Reference: OR-0008519/01
Customer reference: EN010141

20 July 2026

ENVIRONMENT AGENCY'S DEADLINE 5 RESPONSE

EAST PARK ENERGY

Title :  
Figure 9b: Risk of Flooding from  
Surface Water - Climate Change (East  
Park Site C & D)

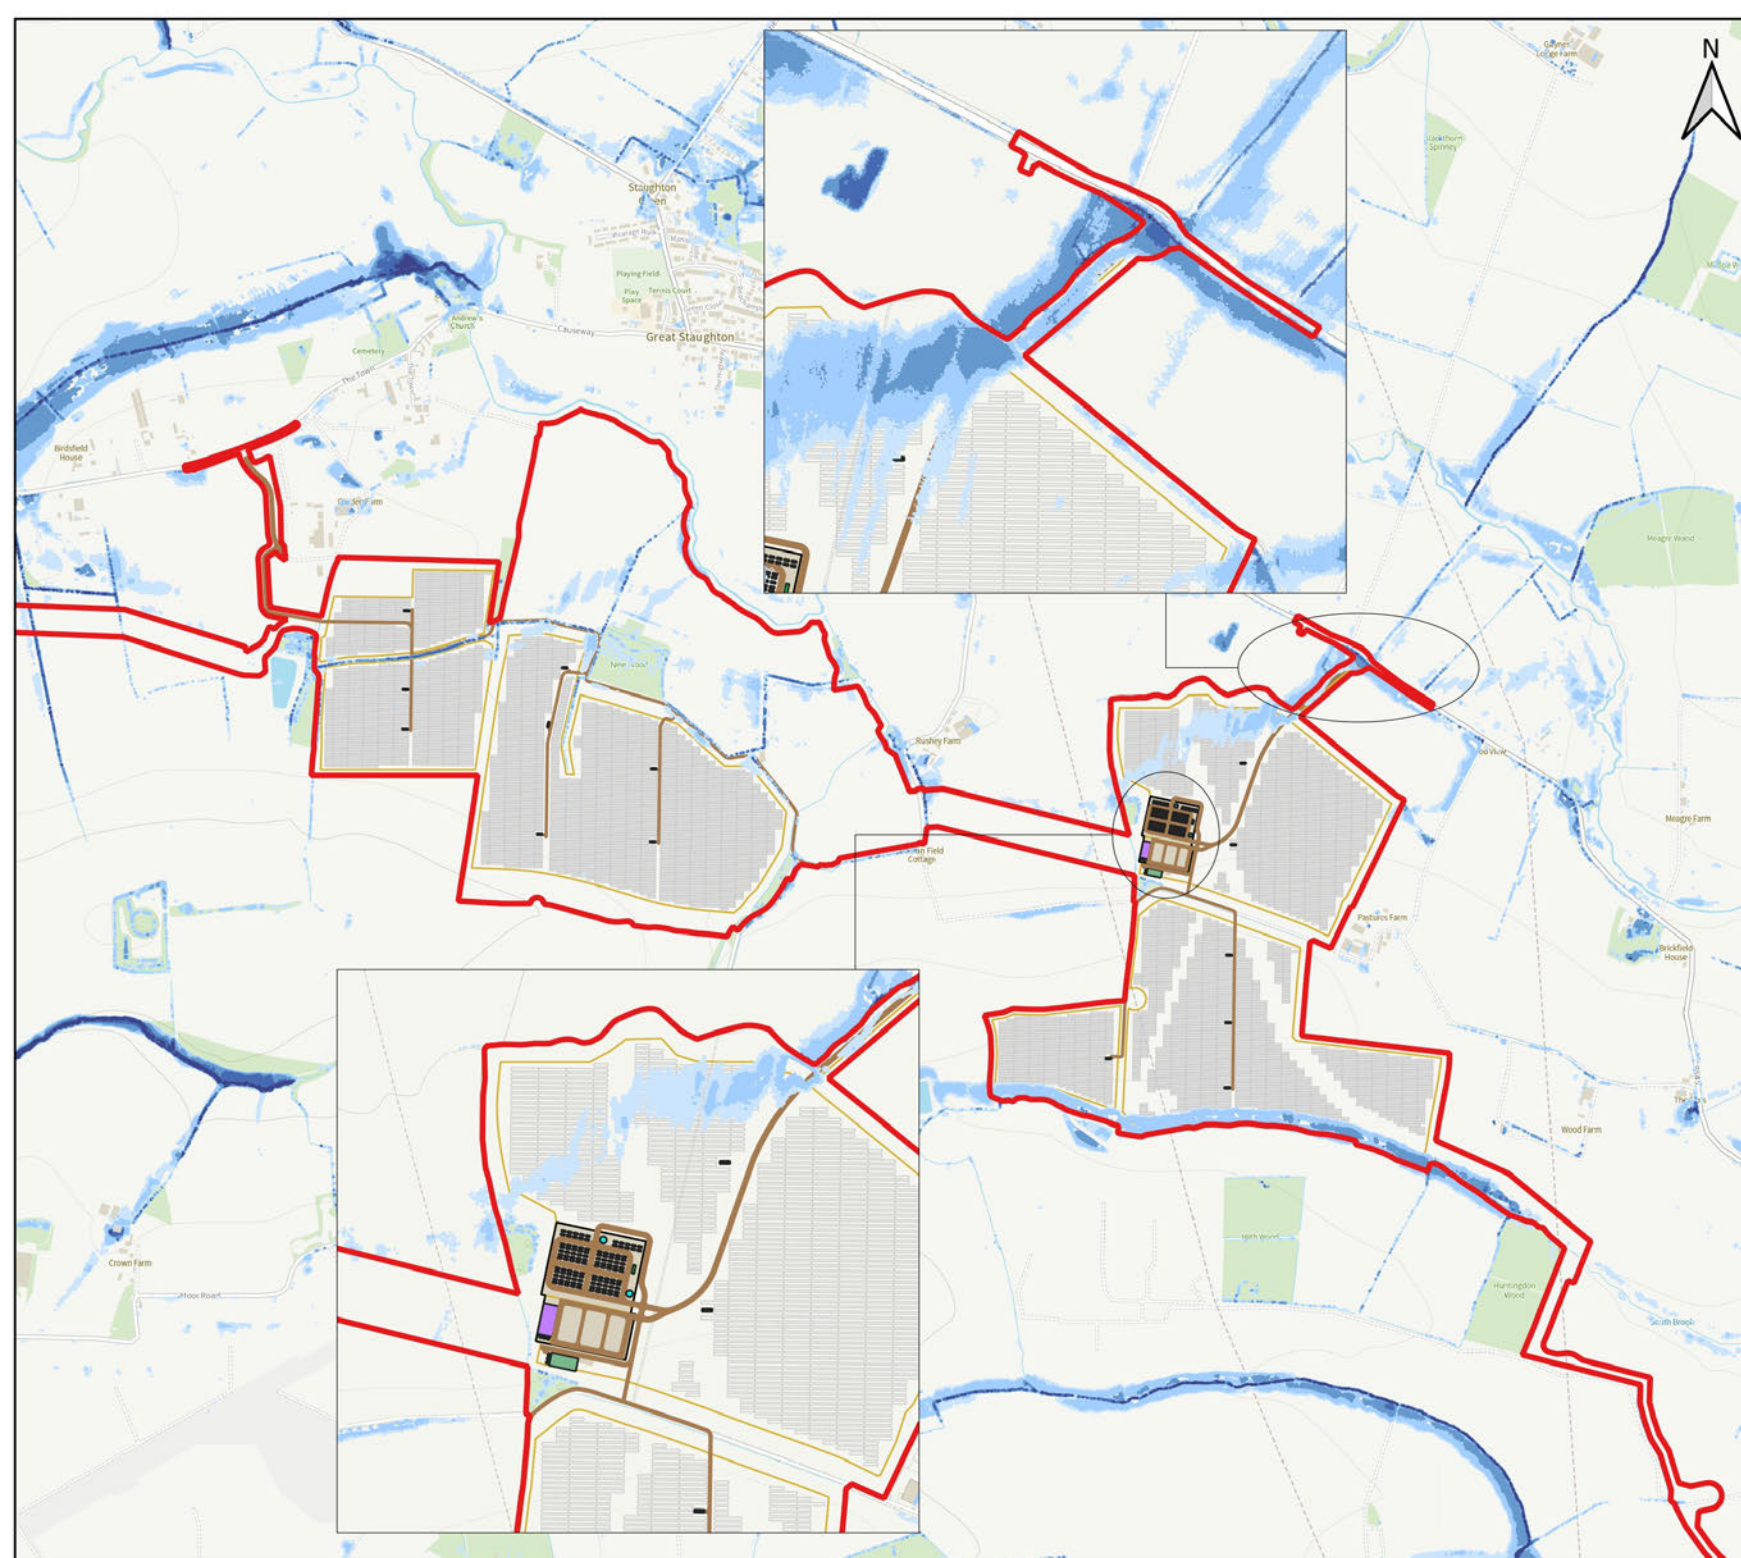
The updated maps presented in Figures 9a, 9b and 9c (revision 3) of the Flood Risk Assessment [\[REP4-018\]](#) appear to be based on the *Flood Map for Planning – Surface Water Spatial Planning Depths* dataset with climate change applied. However, it is important to note the climate change allowance incorporated within this dataset is the 2070s Upper End allowance, rather than the Central allowance referred to in Section 3.5.4 (page 12) of the updated Flood Risk Assessment.

This discrepancy does not materially affect the conclusions of the FRA. In fact, the assessment has been undertaken using a more precautionary climate change allowance for surface water flood risk than is described within the FRA text. We therefore raise this as a minor reporting inconsistency only, rather than a technical concern.
